**WEST SUSSEX COUNTY COUNCIL
INFRASTRUCTURE CONSULTATION**

SUBJECT: A/8/09

2 Arlington Crescent, East Preston

Erection of timber gates

PLAN ①

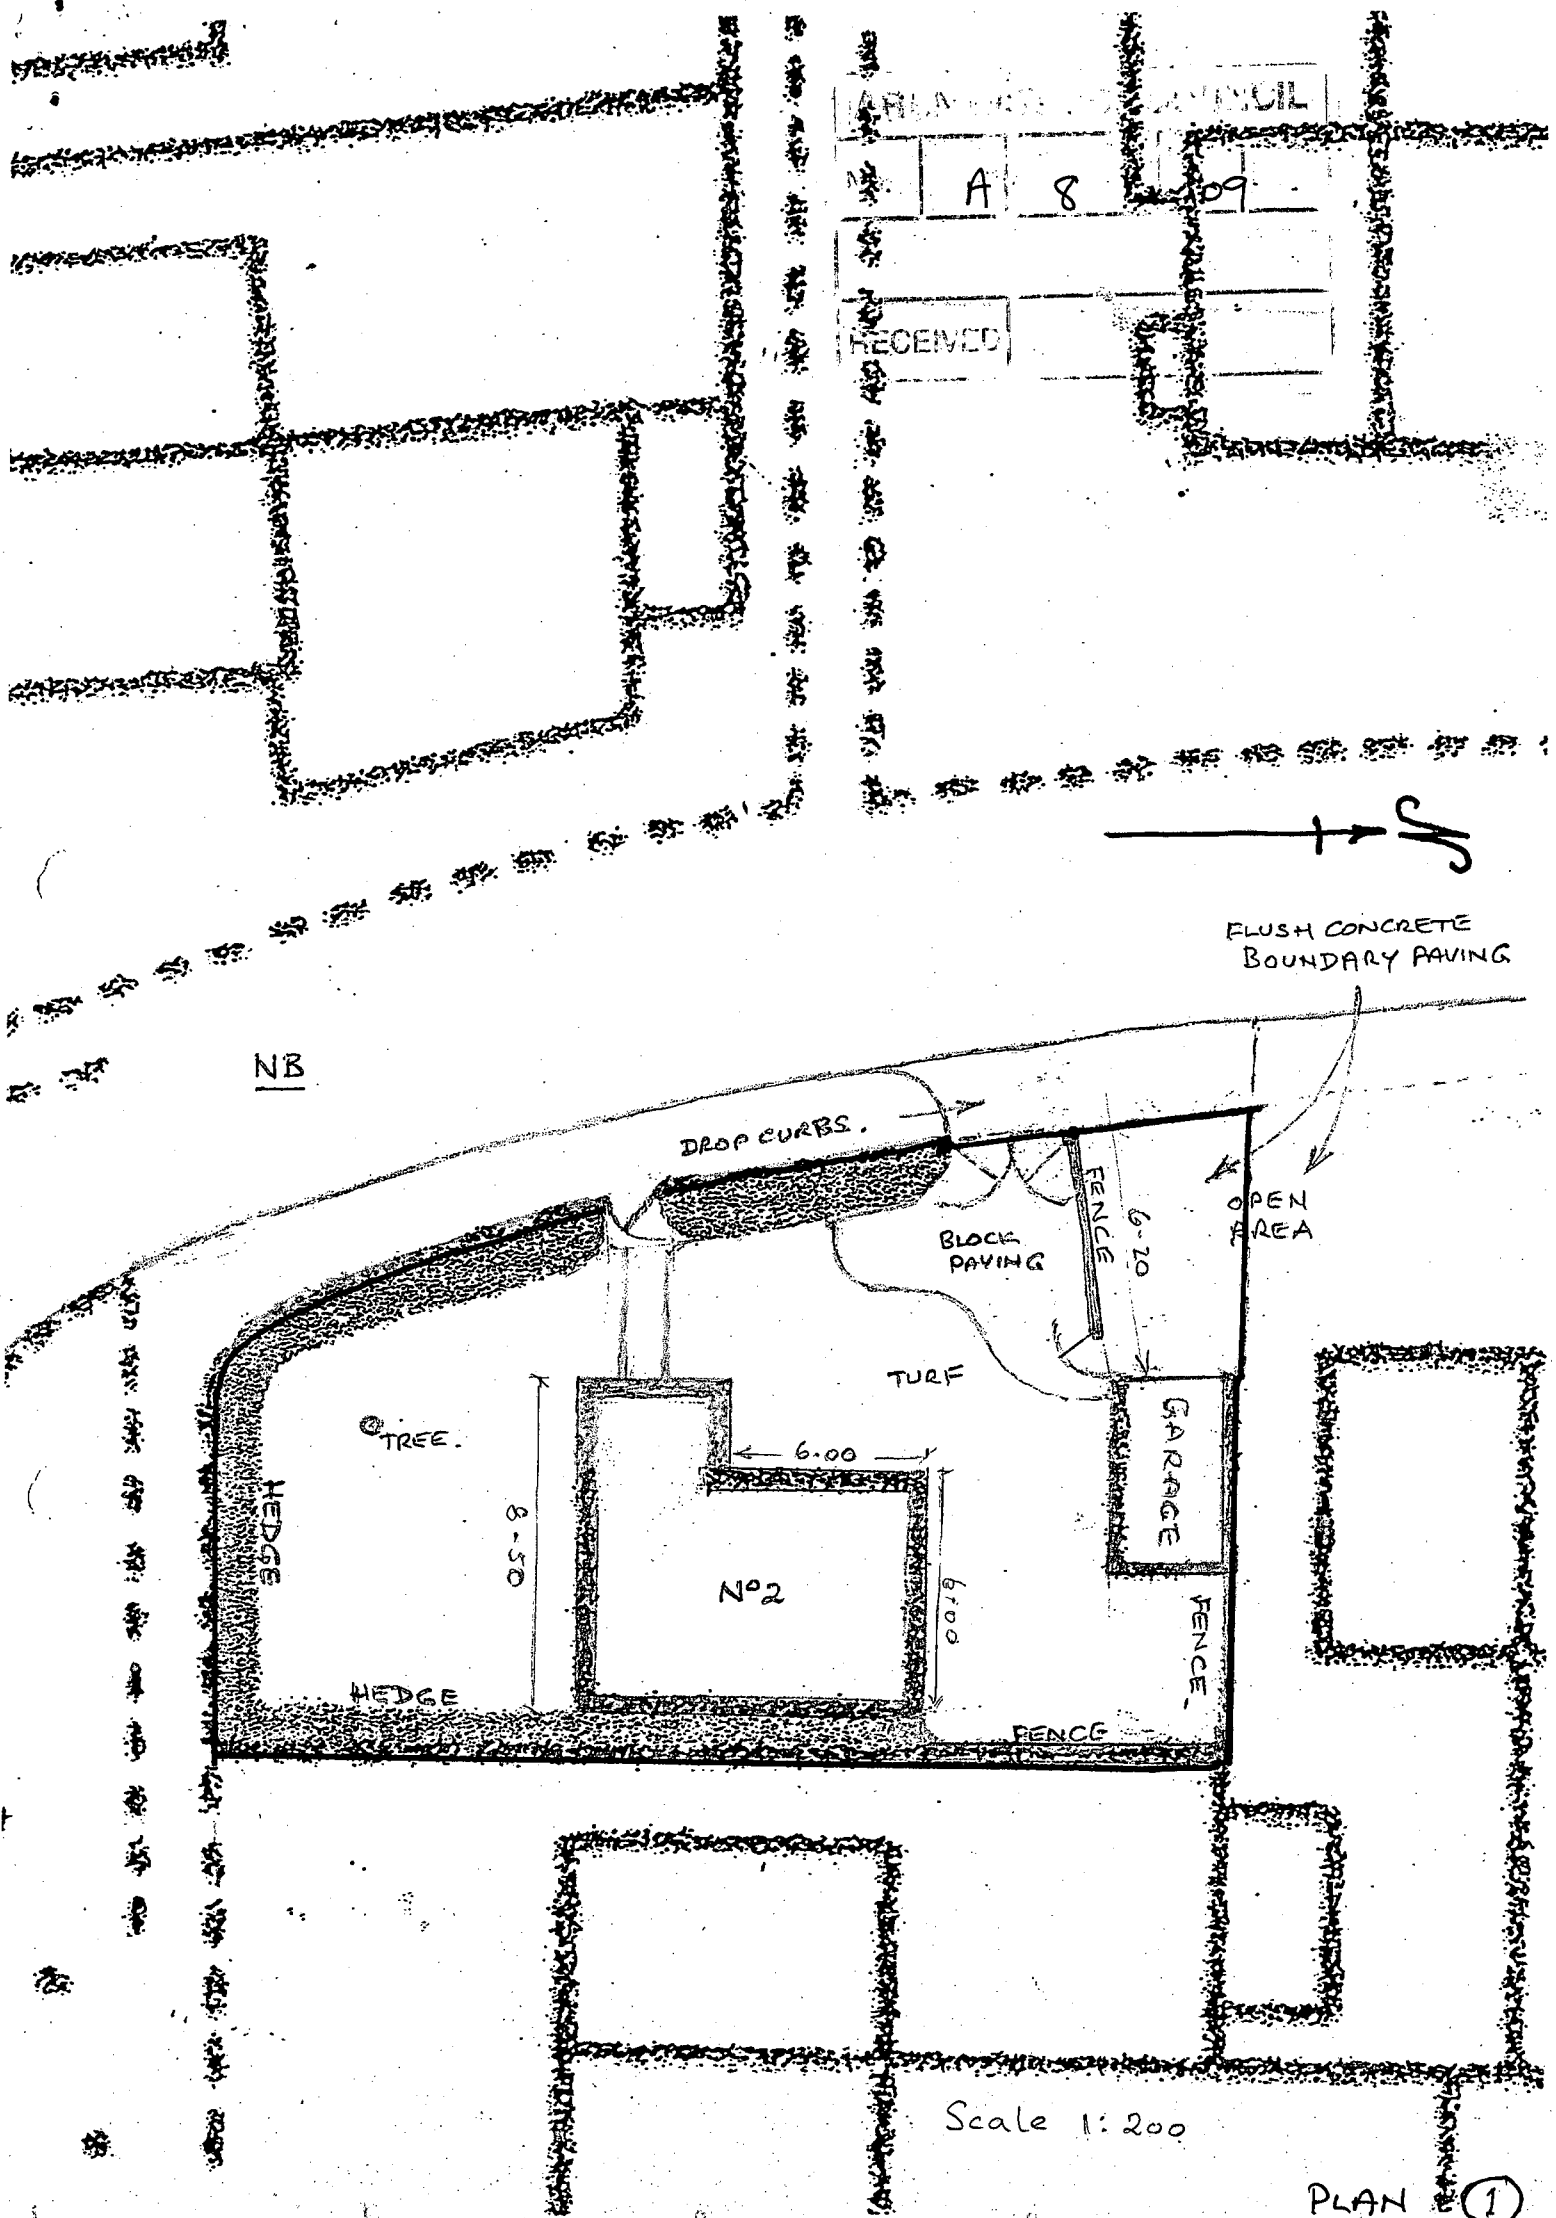
The proposal is for provision of gates with access onto Arlington Crescent. The access point has already been approved by Western Area Office, and therefore no visibility issues are considered. The gates themselves should be placed 5m back from the near side carriageway in order for vehicles to leave the highway whilst queuing for the gates to open.

Any gates provided at the new site vehicular access shall open away from the highway and be set back a minimum of 5 metres from the nearside carriageway edge of the adjoining highway.
